Subject: F/9/14/PL - Application for outline permission with some matters reserved for 45 new dwellings and new access. Lane south of Burndell Road, Ford/Yapton. WSCC highways and transport response dated 29th July 2014

**WEST SUSSEX COUNTY COUNCIL
STRATEGIC PLANNING CONSULTATION**

SUBJECT: F/9/14/PL - Application for outline planning permission with some matters reserved for 45 x new dwellings and new access. This application also lies within the parish of Yapton.

LOCATION: Land south of Burndell Road, Ford, West Sussex, BN18 0HR

TITLE: Proposed Access and Highway
Improvements Plan

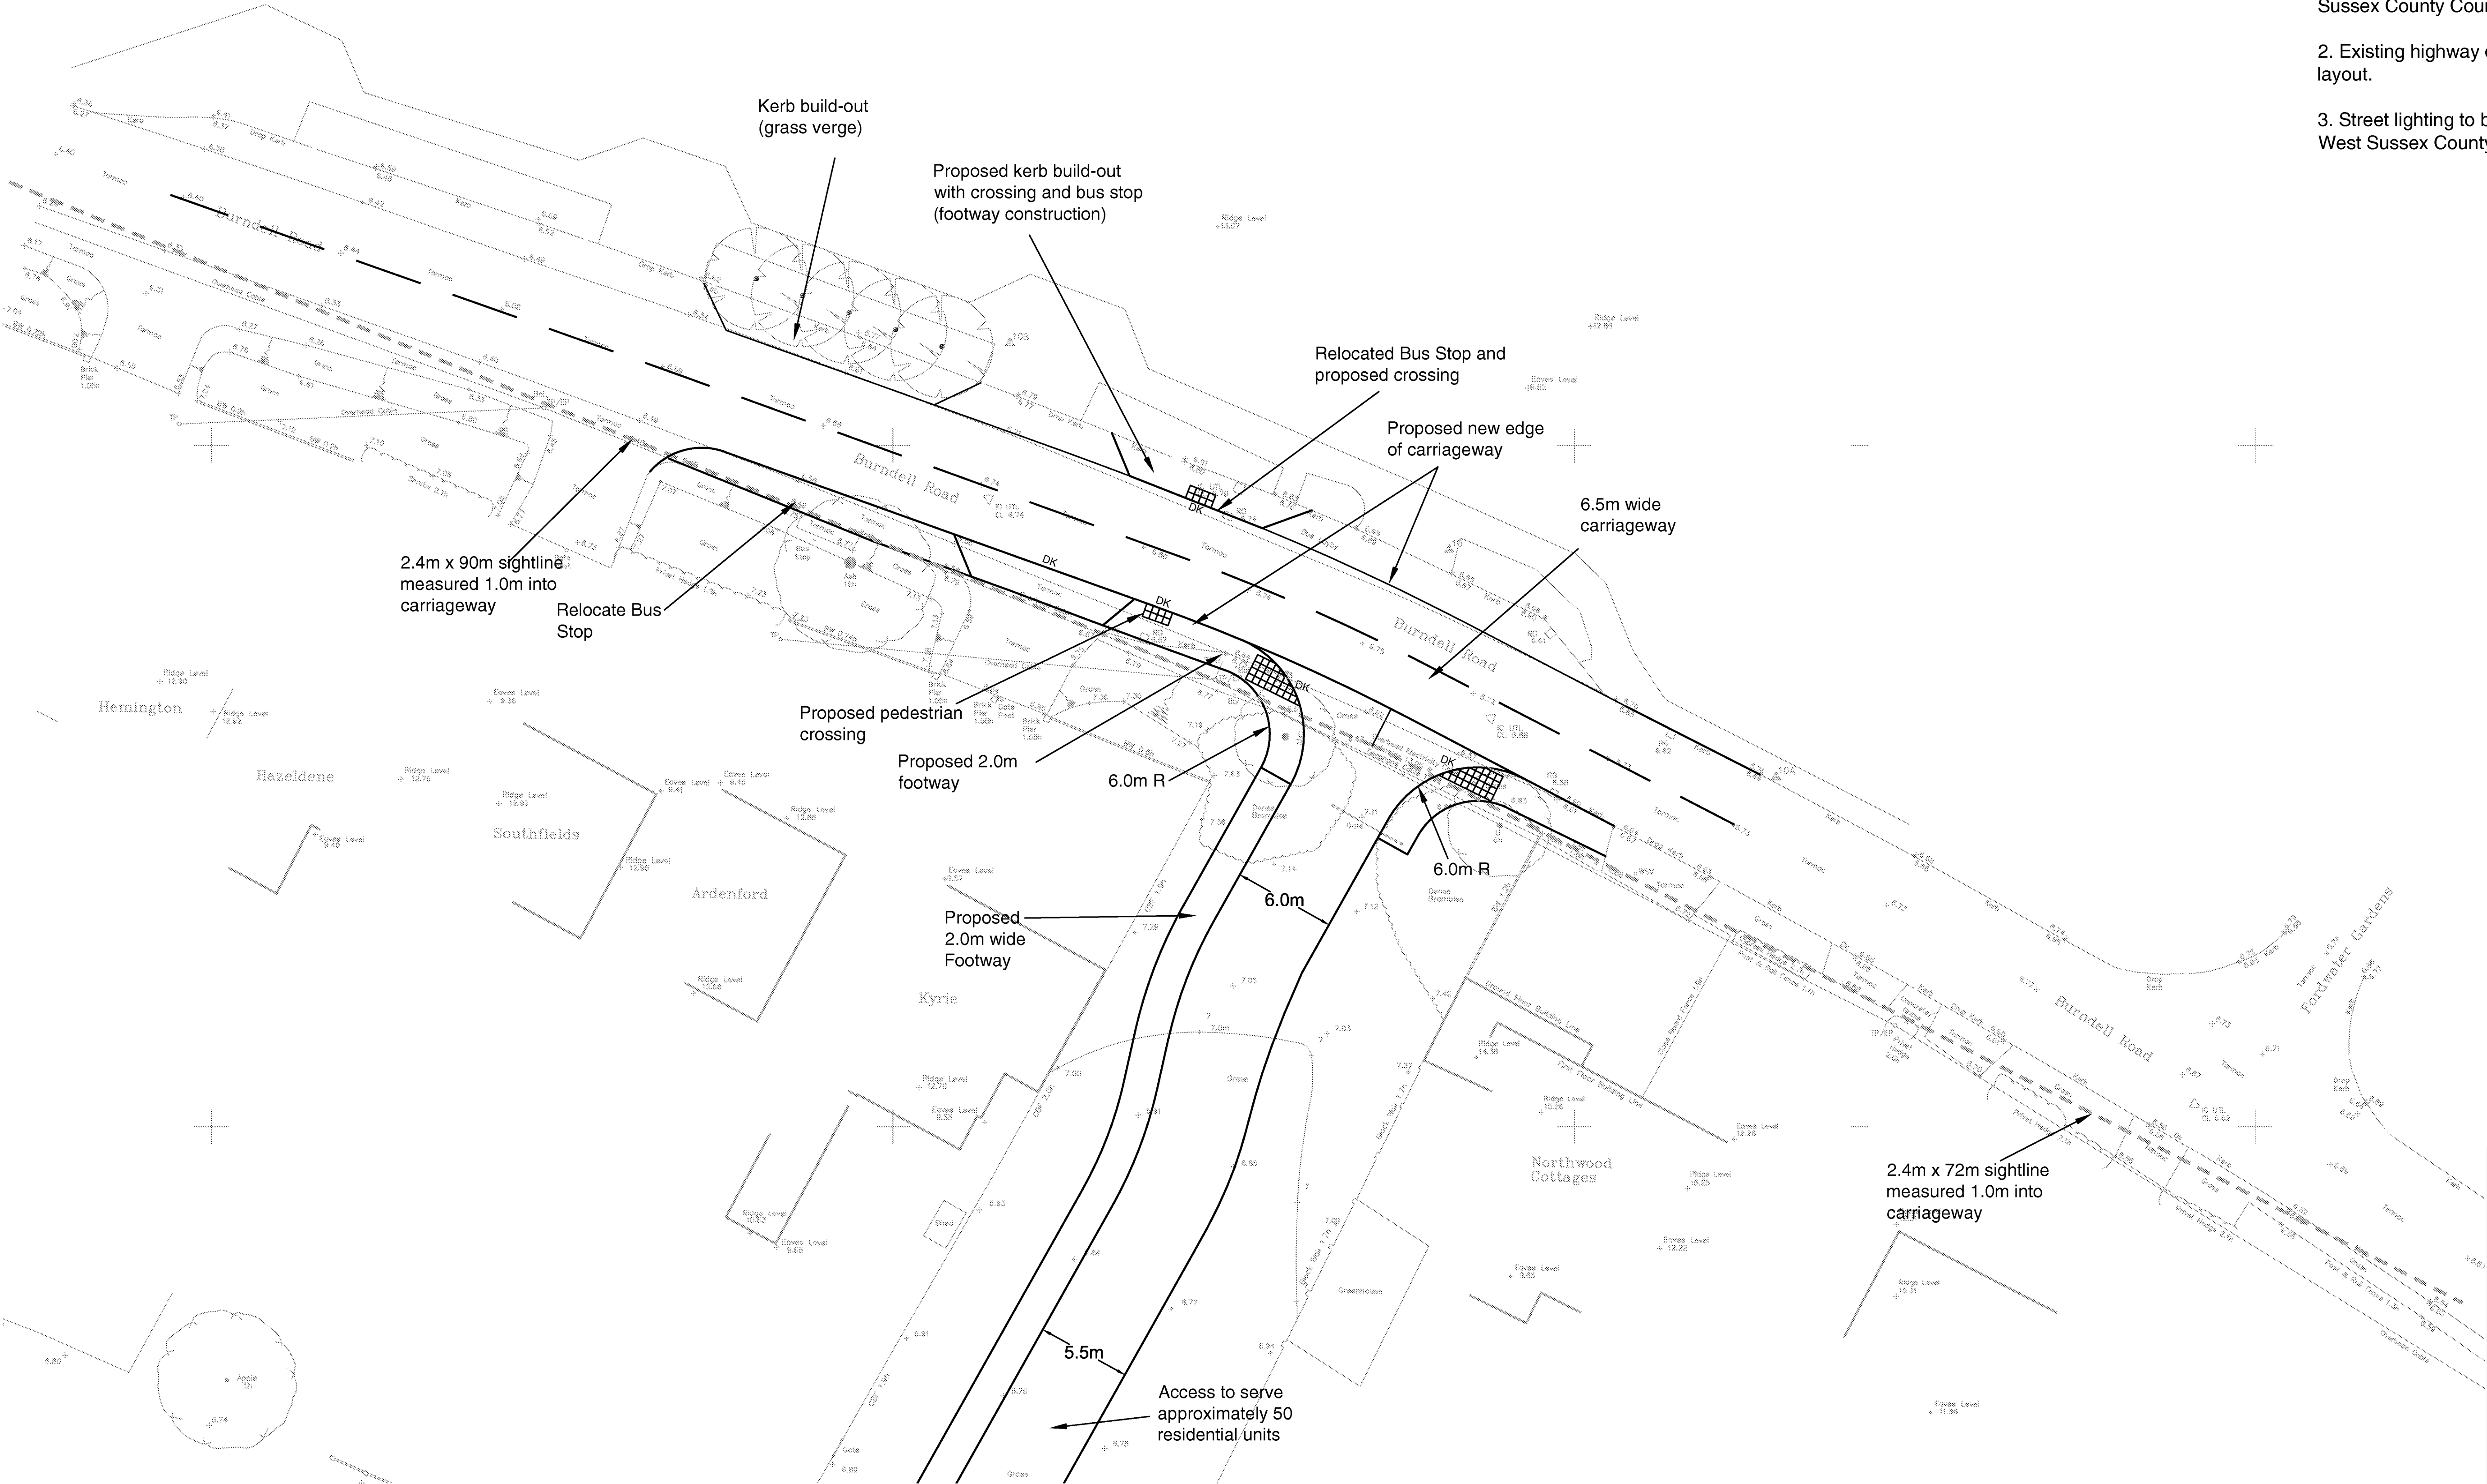
Drawing No. TSP/BRO/P2551/02 shows an uncontrolled pedestrian crossing with tactile paving across Burndell Road immediately adjacent to a re-sited bus stop. A blind or partially sighted pedestrian crossing Burndell Road south to north will have their route

across the road blocked by a bus standing at the bus stop which could lead to vehicle/pedestrian collisions.

It is proposed that there will be new 2.0m wide footways on both sides of the access road where it meets Burndell Road with tactile paving to assist blind and partially sighted pedestrians to cross the new access road. The audit team are concerned that the section of new footway on the east side of the access road is very short and does not lead to a continuous footway on the south side of Burndell Road. Blind and partially sighted pedestrians may become confused by the lack of footway and may lead to such pedestrians attempting to cross Burndell Road which could result in vehicle/pedestrian collisions.

With regard to the Designer's Response to problem 2.1 of the Audit, what is written does appear to address the recommendation to move the bus stop. However, from on-site observation and scrutiny of the application plan (TSP/BRO/P2551/02H), it now appears possible to retain the bus stop on the northern side of the road where it is at present. Other than the new section of footway shown constructed on the northern side of Burndell Road to accommodate the pedestrian crossing point, the section of lay-by found east of the proposed crossing point can now be retained generally as-is with some kerbing adjustments and erection of bus shelter, thereby meeting the recommendation contained in the RSA. This would then accommodate a bus largely clear of the carriageway opposite the proposed access point and clear of the proposed pedestrian crossing point west of the bus stop. All works would have to be undertaken through a S278 Agreement entered-into with the Highway Authority.

In order to remove the possible vehicle/pedestrian conflict, drawing TSP/BRO/P2551/02H now shows a re-located uncontrolled crossing approximately 24m to the west. This would allow pedestrians to cross away from the bus stops and waiting buses.

Footway now removed from proposals as shown on drawing TSP/BRO/P2251/02C.
